2 February 2011

Re Planning Application M/1/11 Mr M Birch – Retreat, Rose Avenue, PO22 7TG

DRAWING	SCALE
PROPOSED FIRST FLOOR	1/50
DATE:	DECEMBER 2010
DRAWN:	T. Murray
DRAWING:	10/63/3
REVISION:

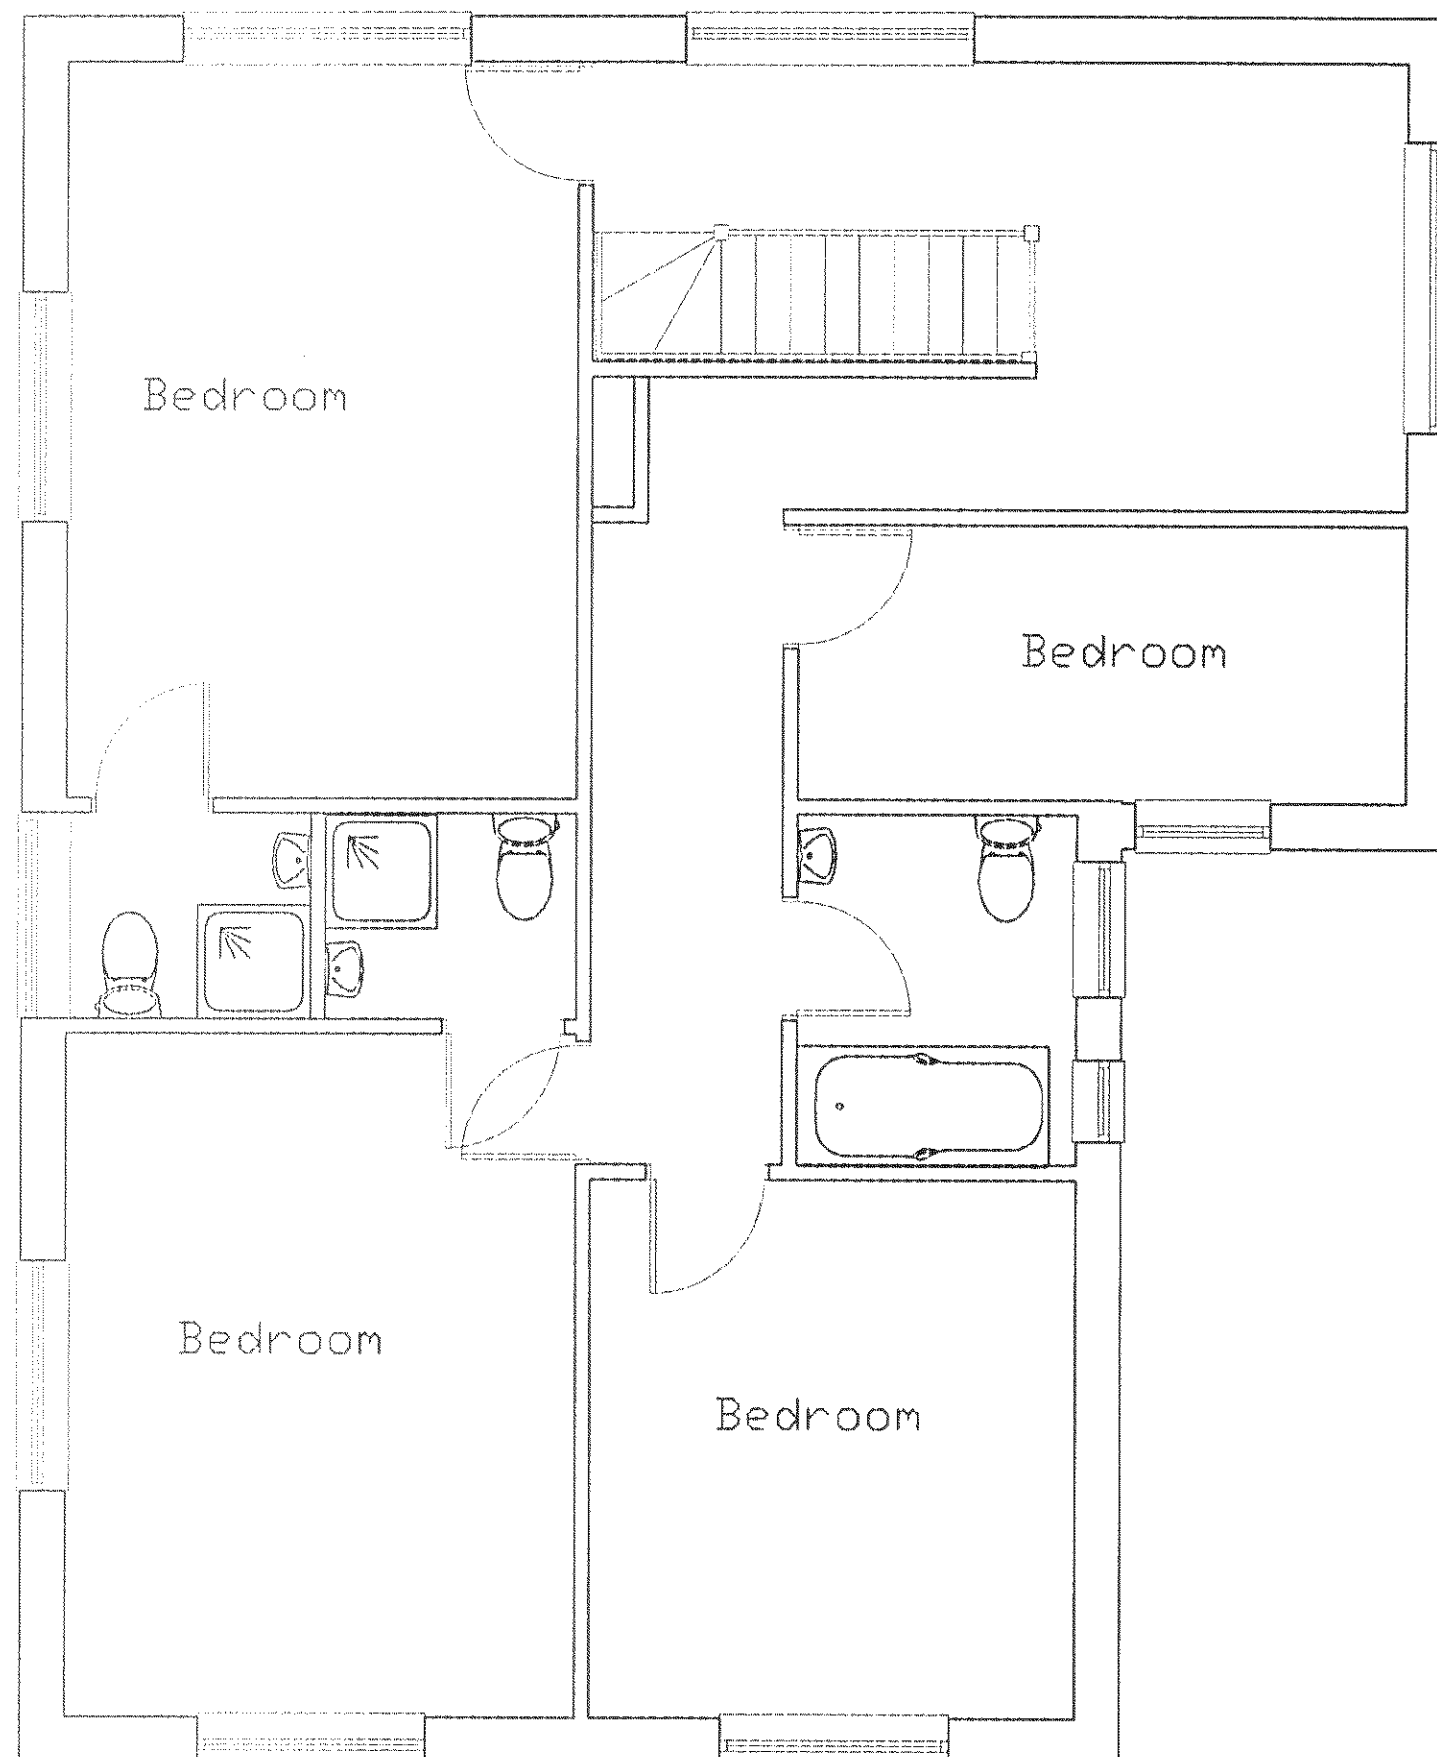
I also believe that the addition of two more shower and toilet facilities may add to the sewage and drainage issues that already exist when the water table levels are high as a result of the old Victorian pipework which is cracked and needs renewing.

DRAWING: 10/63/4 REVISION:

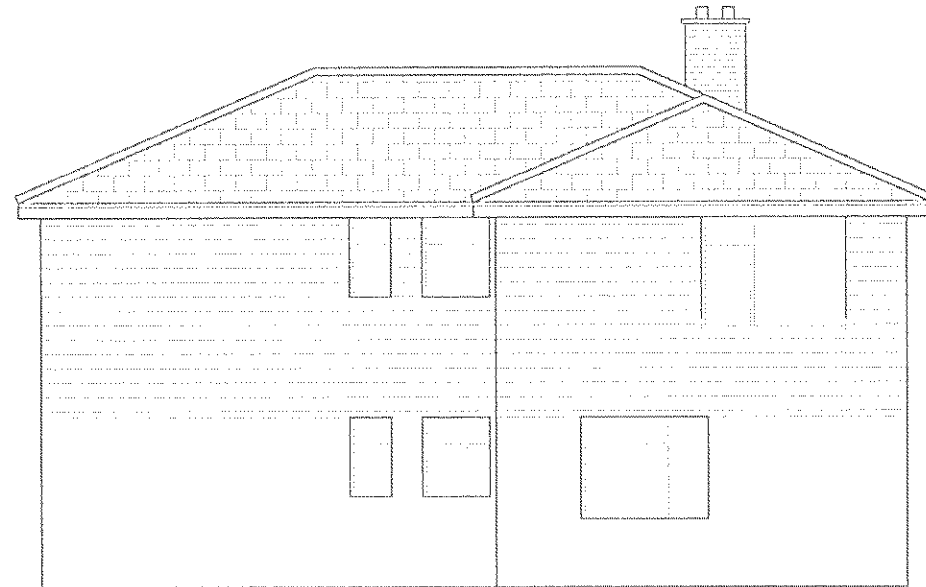
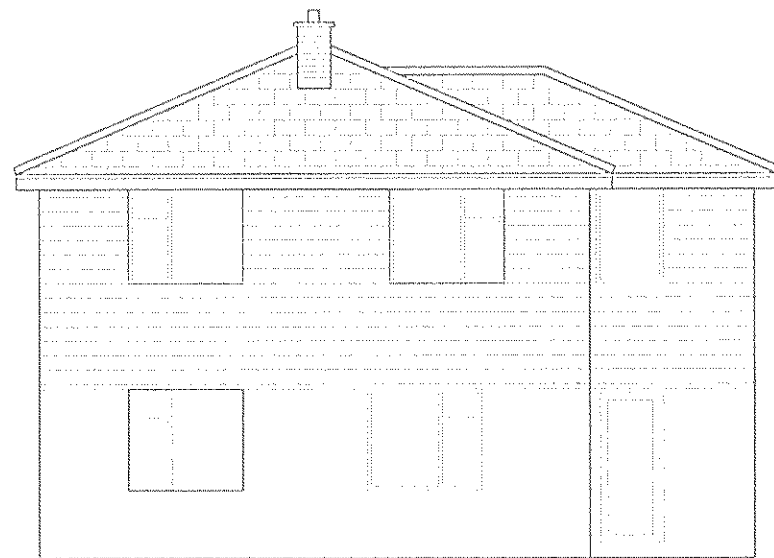
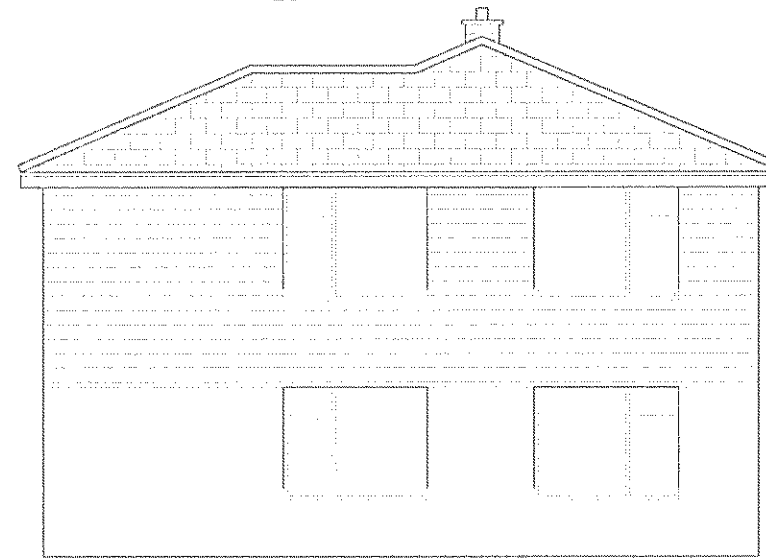
I believe that this development will be out of keeping with the road/estate as all properties from the main road up to the Retreat (including Shaw close to the side of the Retreat) are single story properties or chalet/loft conversions. Although there are properties further along Rose Avenue with two floors, they are in a section together and do not overshadow the bungalows. Furthermore I believe that as the bedroom window closest to our property on the east side of the Retreat will now be on the second floor and above fence line height, this may overlook our back garden and so remove some of the privacy we have.

As the proposed, new second floor extension is to the North of our property I believe this will have an impact on the amount of daylight we receive on that side of our property as the second floor will now overshadow that side of our bungalow.
